Ribble Valley Borough Council  
Housing & Development Control

Application no: **3/2023/0533**

Address: **Land Adjacent to Hawthorn Cottage Slaidburn Road Newton in Bowland BB7 3EB**

Proposal: **Proposed demolition of former estate workshop and erection of a two storey detached dwelling. Resubmission of application 3/2022/1094.**

6510 -002 REV **A**

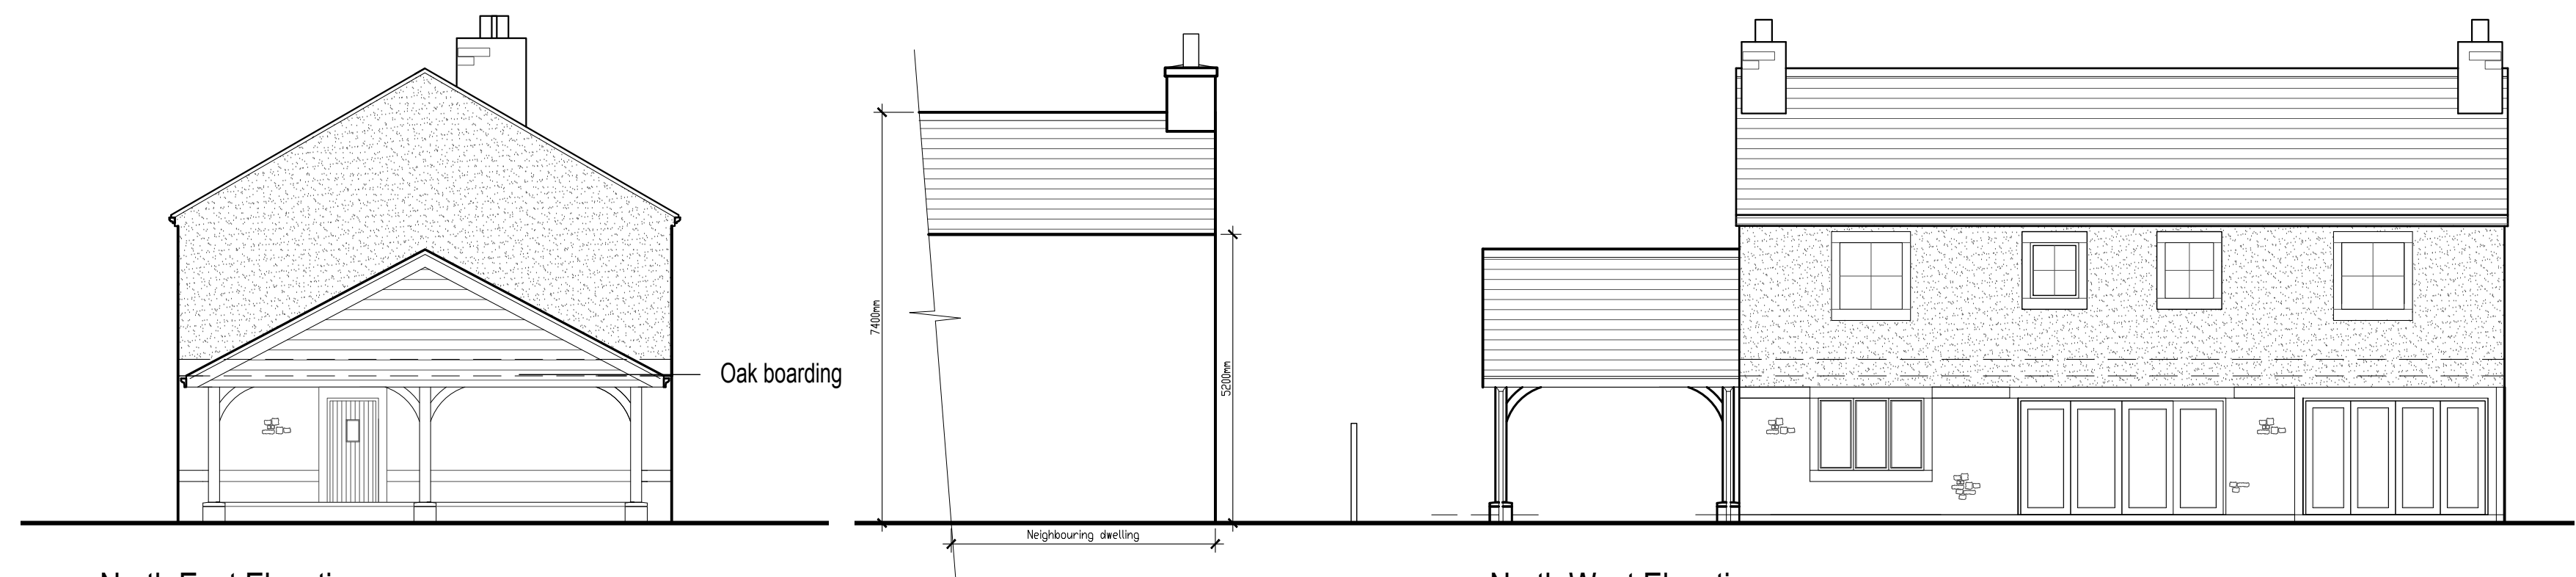
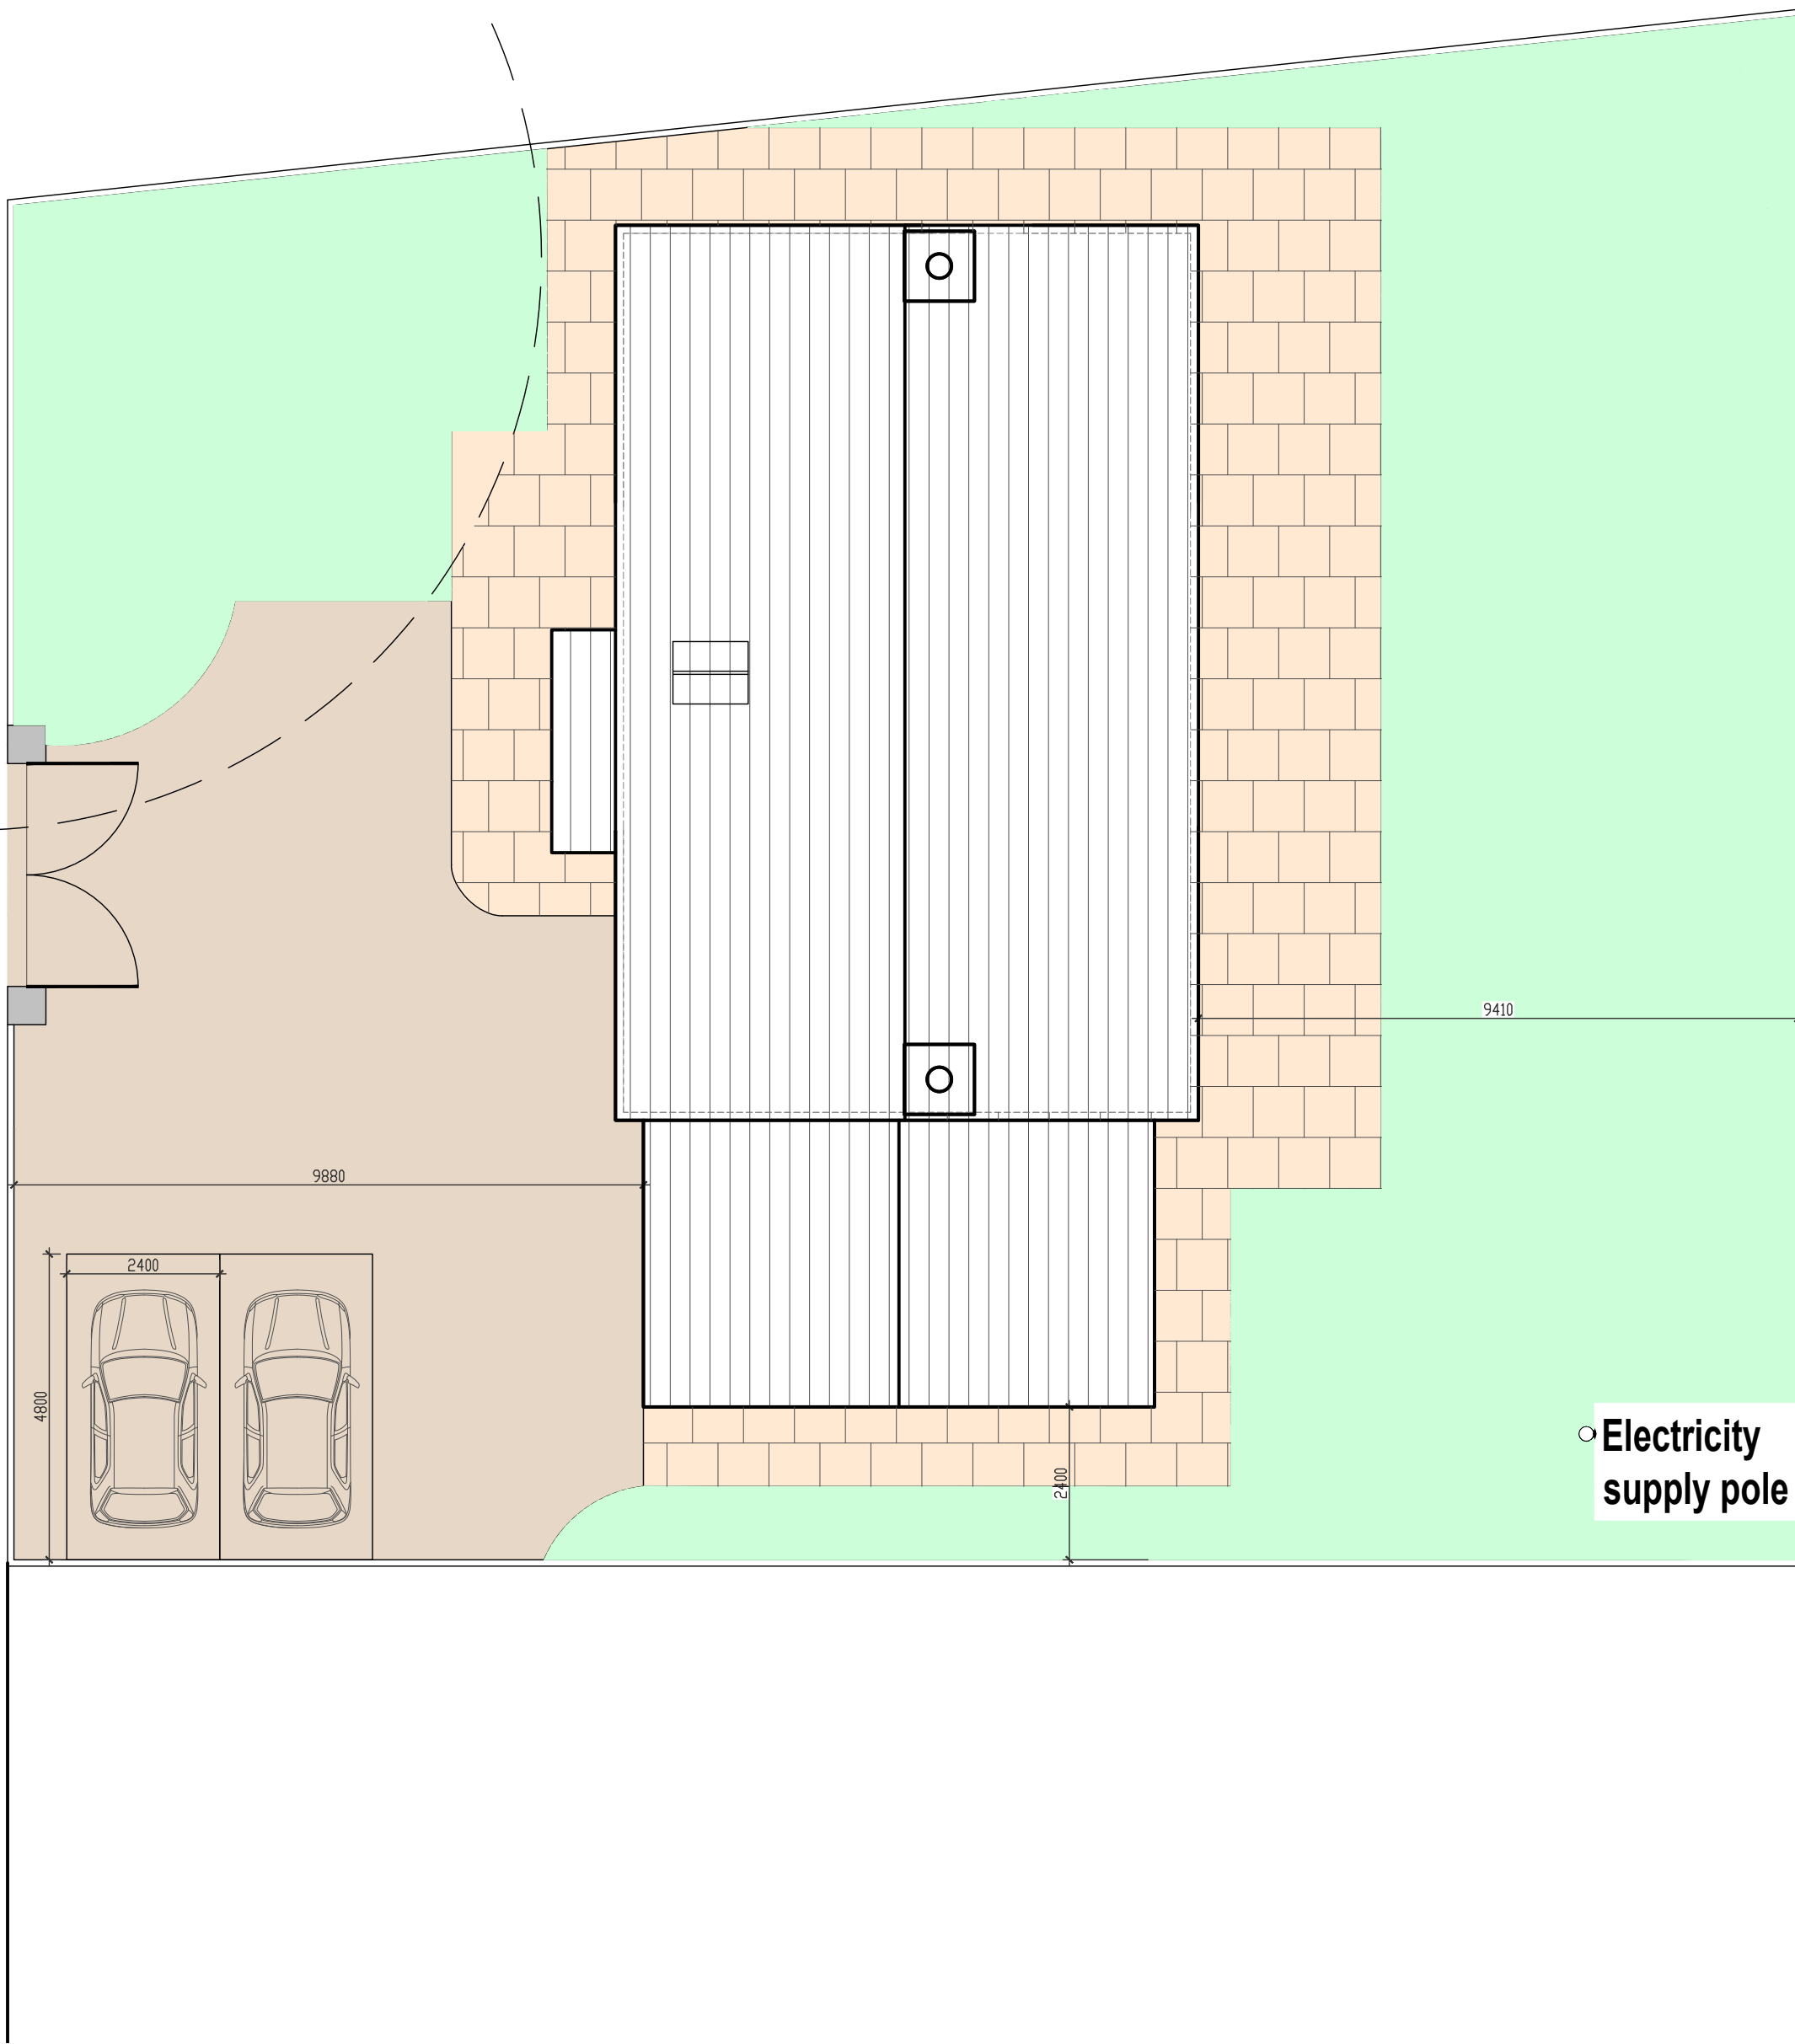
The LHA have reviewed SPA drawing number 6510-002 Rev A titled "Proposed New Se Dwelling (Re-Designed)" and are aware that the 3 car parking spaces can be provided for the 4 bed dwelling which complies with the LHAs parking guidance as defined in the Joint Lancashire Structure Plan.

The LHA will condition that a minimum of one car parking space has access to an electric vehicle charging point and some form of cycle storage provision is provided.

2. The development hereby permitted shall not be occupied until such time as the parking and turning facilities have been implemented in accordance with SPA drawing number 6510-002 Rev A. Thereafter the onsite parking provision shall be so maintained in perpetuity.
